Rezoning Transportation Analysis

Petition Number: 2020-157

General Location Identifier: Tax ID: 07106117

Date	Description
11-30-20	First Review (EL)
12-28-20	Second Review (EL)

REZONING PETITION
#2020-157

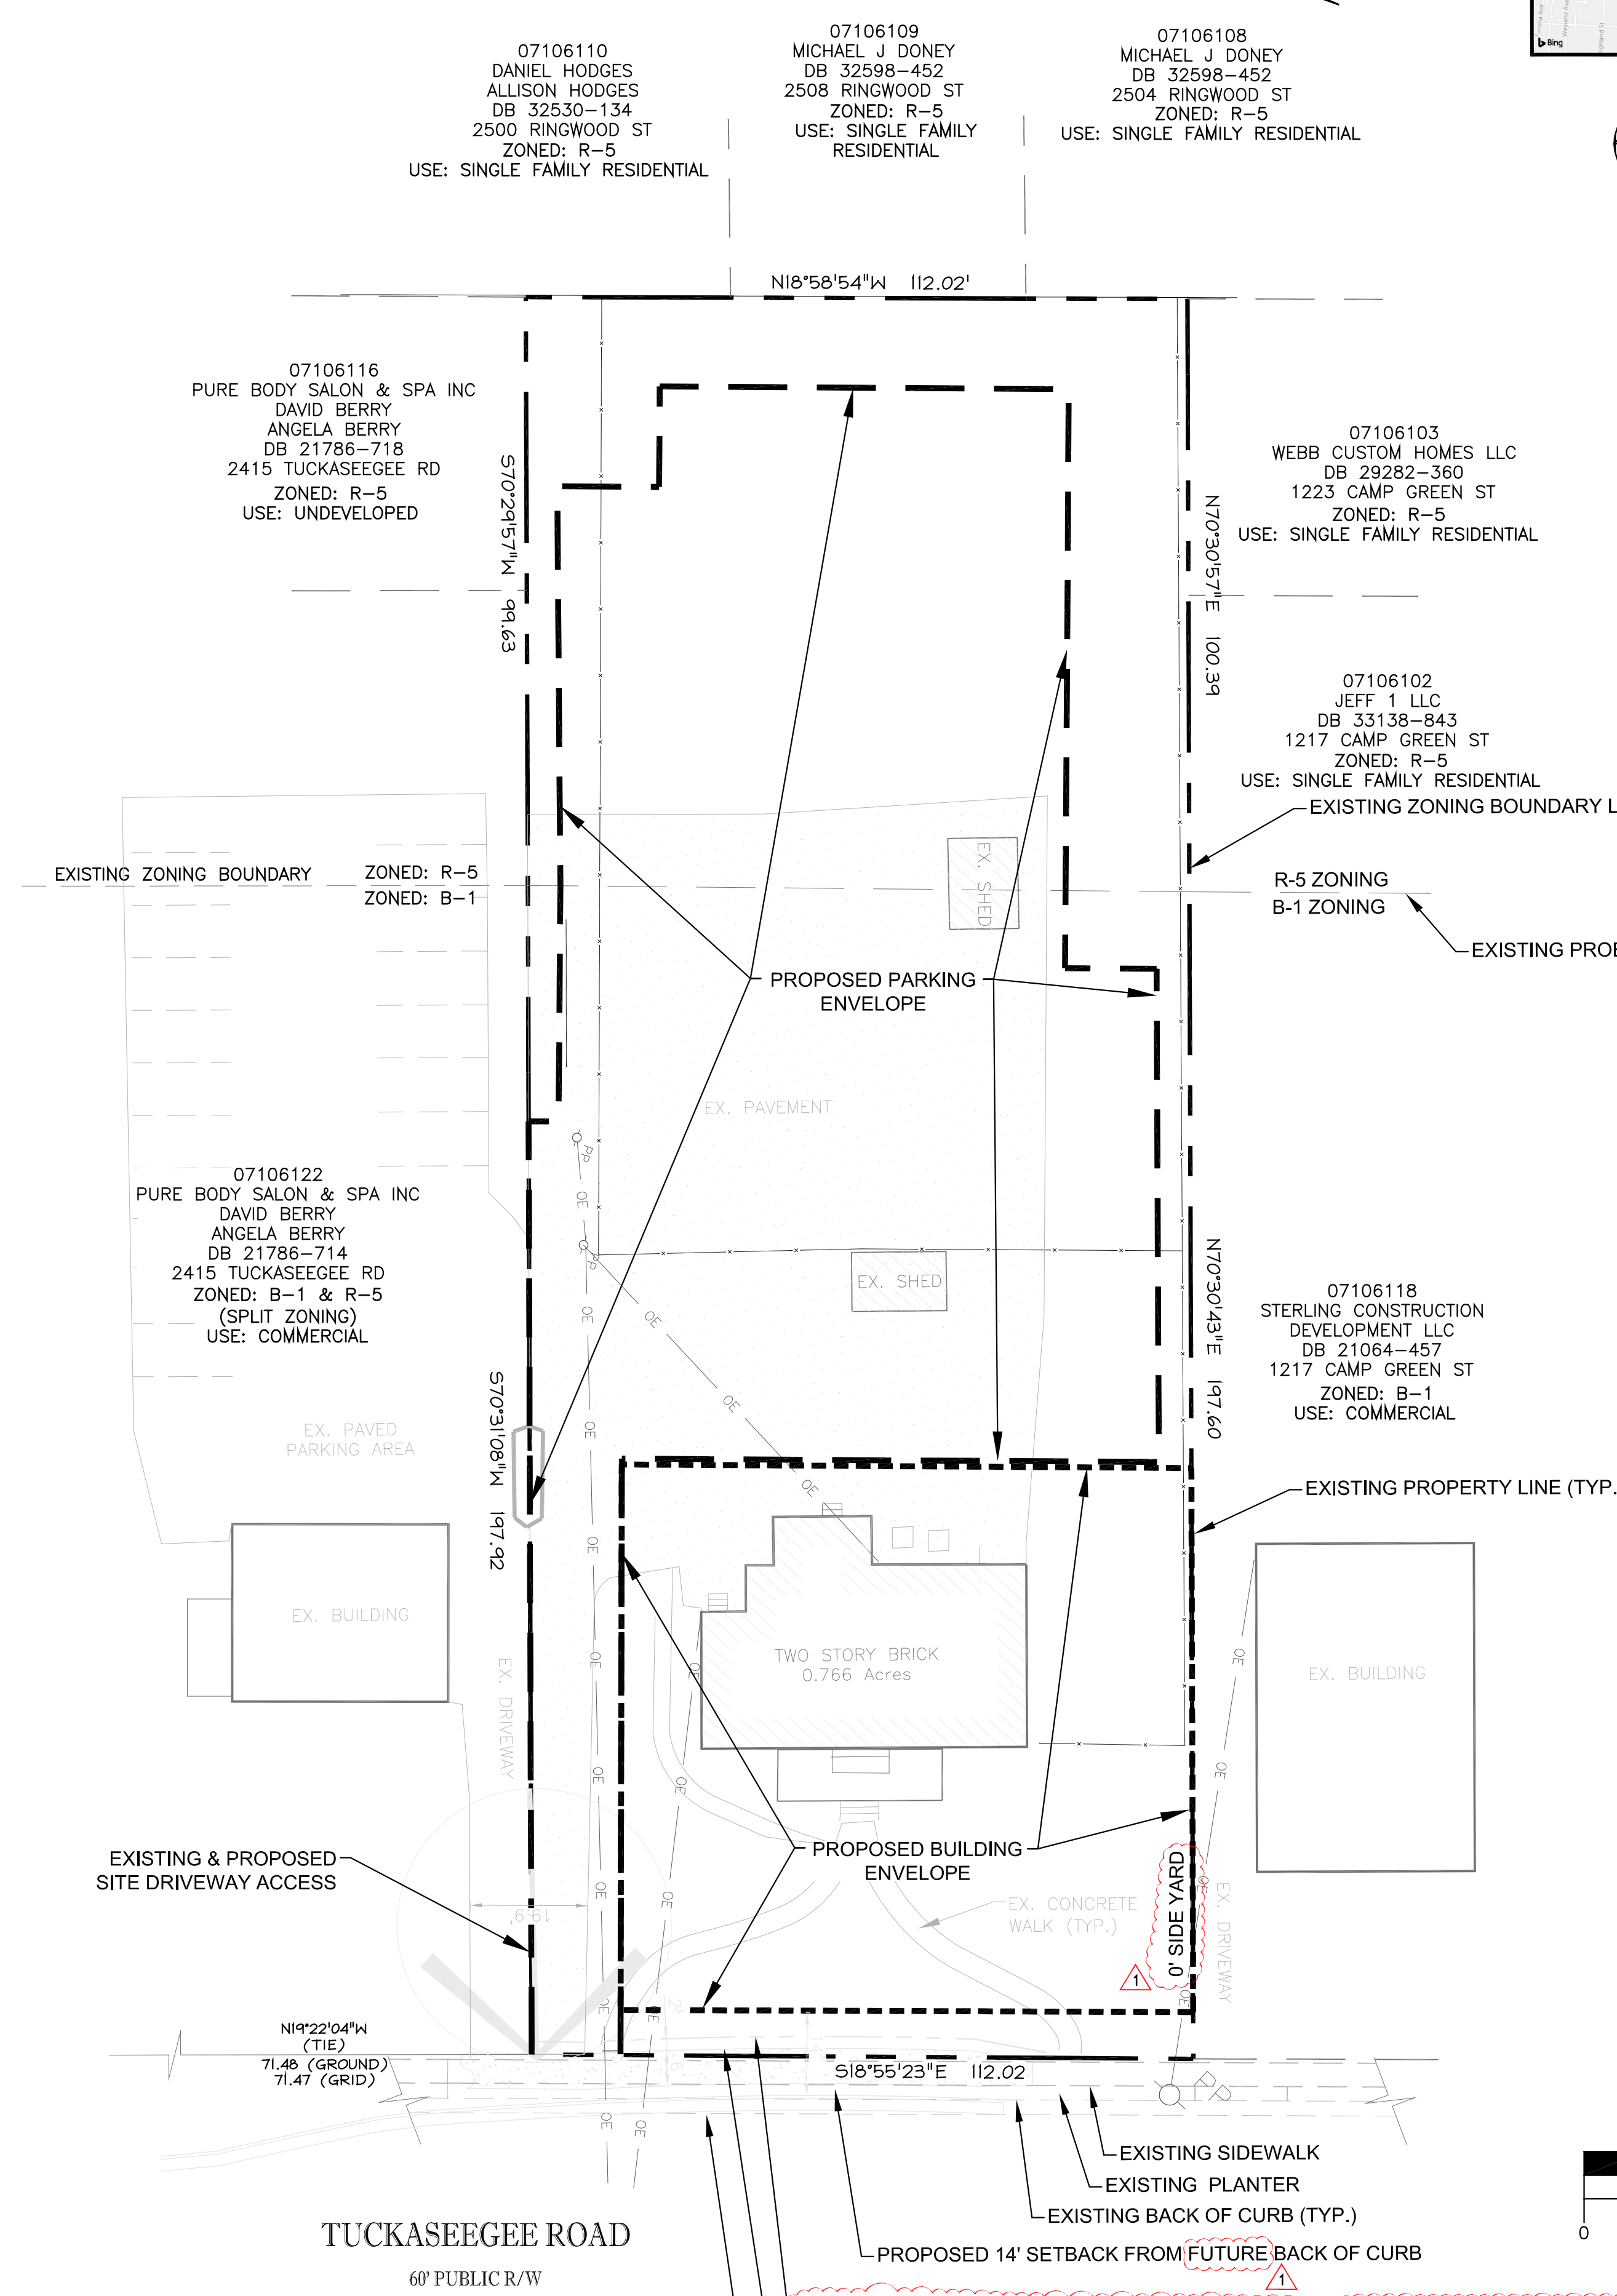
Label and dimension the curb and gutter from the centerline for each road on the site plan.

4. **New comment (site plan dated 12.15.2020):** Revisions are needed on the site plan and conditional note (Section 7.B) to relocate the proposed 8-foot planting strip to the Tuckaseegee Road back of curb, separating the proposed 6-foot sidewalk from the roadway, as required within Chapter 19-174 of the City Code, to allow the planting strip to function as necessary.
